Application Ref:	3/2025/0487			 Ribble Valley Borough Council www.ribblevalley.gov.uk
Date Inspected:	04/07/25	Site Notice:	N/A	
Officer:	LW			
DELEGATED ITEM FILE REPORT:				APPROVAL

Development Description:	Single storey rear extension.
Site Address/Location:	19 Pendle View, Brockhall Village, Old Langho, BB6 8AT.

Title: Proposed Plans	Drawn: AW
Client: Samina Fareed	Checked: NME
Date: 15/04/2025	Paper: A3
Drawing No: HAD3938-03	Scale: 1:100
Revision:

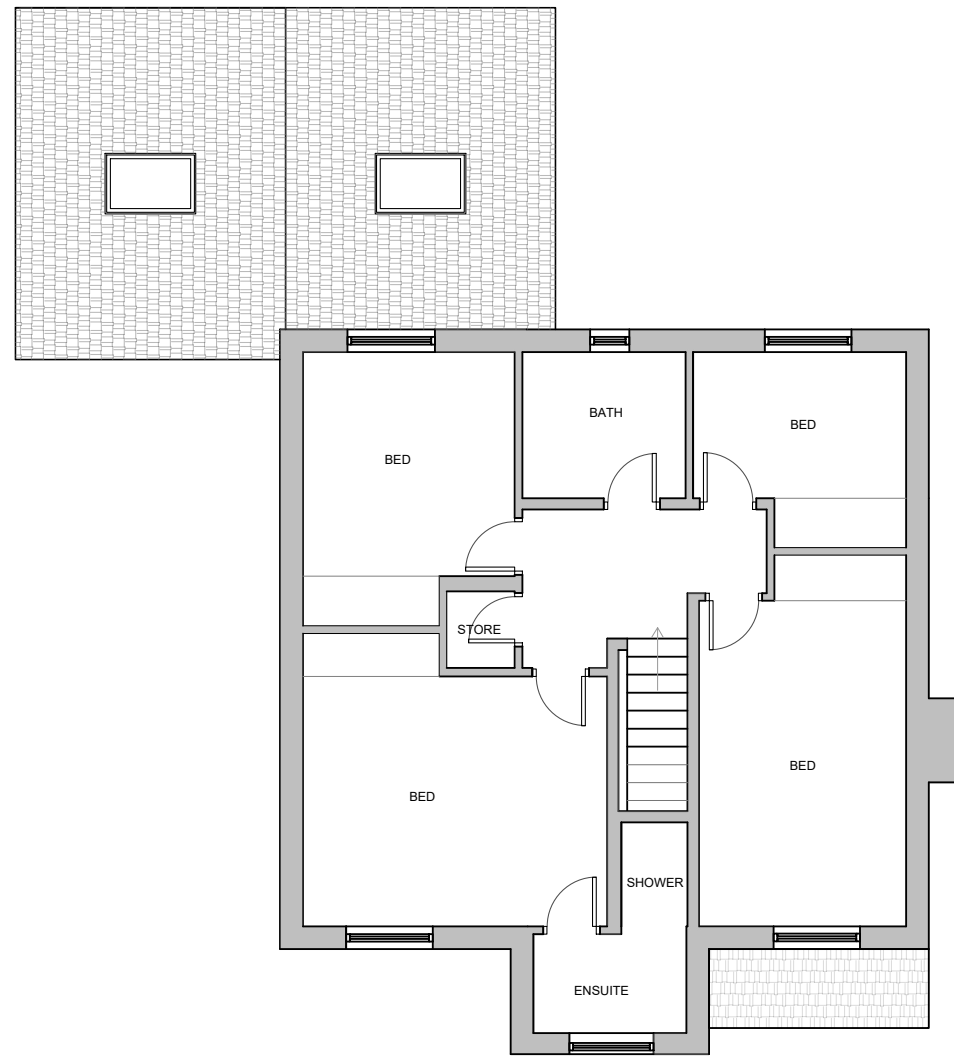
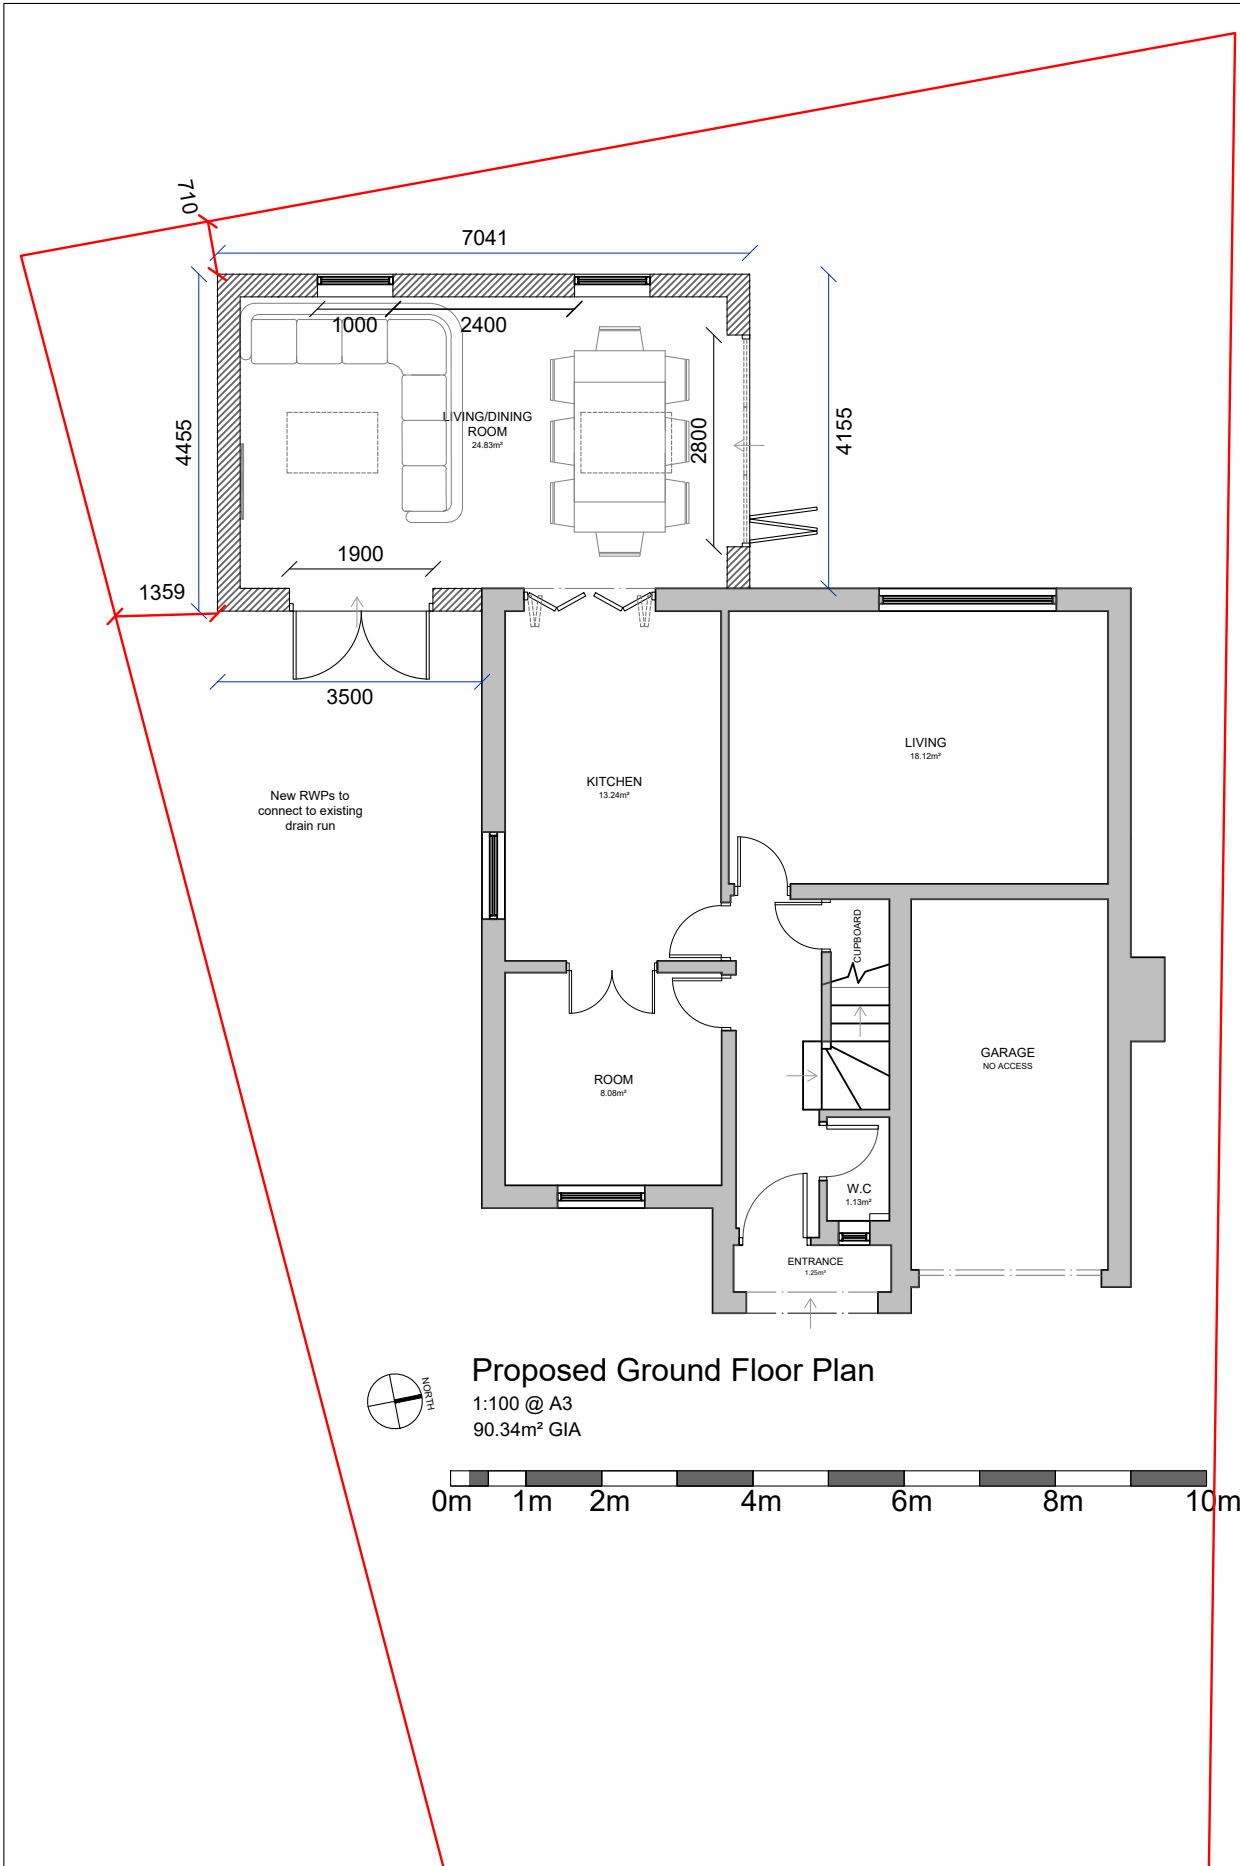
Consent is sought for the construction of a single storey rear extension projecting 4.2m from the rear elevation of the application property and 3.5m from the south facing side elevation with a maximum width of 7m. A pitched roof form would be incorporated measuring 2.4m to the eaves and 3.8m to the ridge.

To the front elevation a set of glazed double doors would be included, along with 2no. windows to the rear and bi-folding doors to the north side elevation.

With respect to materiality, the proposed development would be finished in brickwork, concrete roof tiles and white uPVC windows and aluminium doors.

The openings proposed to the extension would provide views predominately into the private amenity space associated with the application property and therefore it is not anticipated that any new opportunities for direct overlooking or loss of privacy would be resultant.

The extension would also be adequately distanced from nearby residential receptors being sited approximately 6m from the common boundary with no.21 Pendle View and in excess of 10m from the residential dwelling at no.17 Pendle View. As such, it is not considered that the proposal would result in any significant degree of overshadowing, loss of outlook or daylight to neighbouring occupants.

The proposed extension would appear appropriate in size and scale for a single storey extension when read in context with the existing built form of the dwellinghouse and would not read as an incongruous or unsympathetic addition. The proposal would also be finished in materials to match the external appearance of the primary dwellinghouse, including brickwork and concrete roof tiles, ensuring visual integration and further reducing the impact of the development.
